Permit Number: 071275

This is to certify that EVANS MARTIN C & JULIA H EVANS ITS/Bennett Home
 has permission to Add to existing single car garage 11'x11' to create 2 Car garage
 AT 95 CANCORD E 141 F019001

RE: 95 Canco Road – 141 F019 – R-3 – addition to garage – permit #07-1275

**PROPOSED ADDITION
 11'4" X 19'2"
 ABOVE EX. GARAGE.**

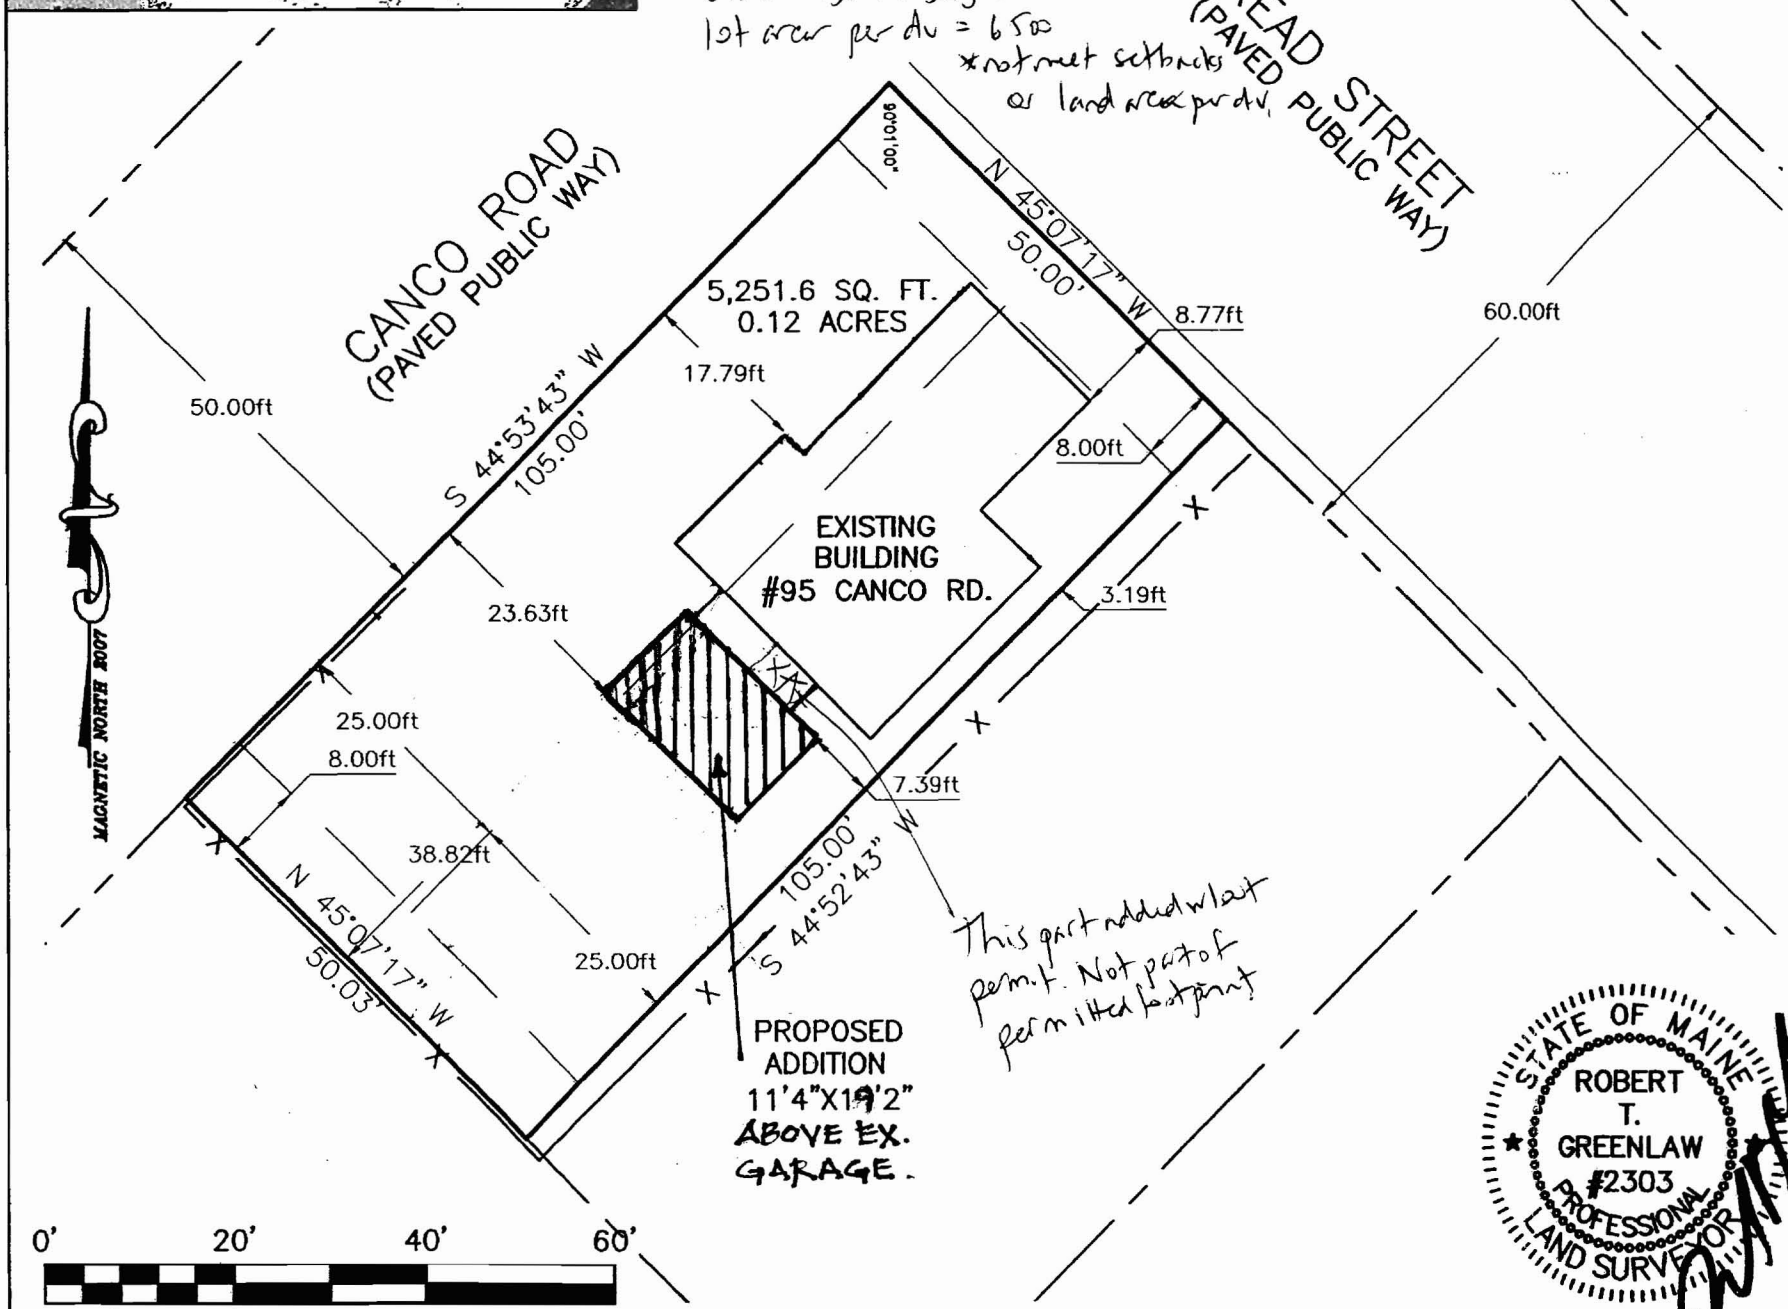
The ordinance, under sections 14-90(d)(1) and 14-90(d)(2), states that the required front yard setback is twenty-five feet and the required rear yard setback is also twenty-five feet. The site plan shows that the front yard setback to the proposed addition is 23.63 square feet and the rear yard setback to the proposed addition is 7.31 square feet. Since the proposed addition is not meeting either the front or rear yard setbacks, your permit must be denied for this reason also.
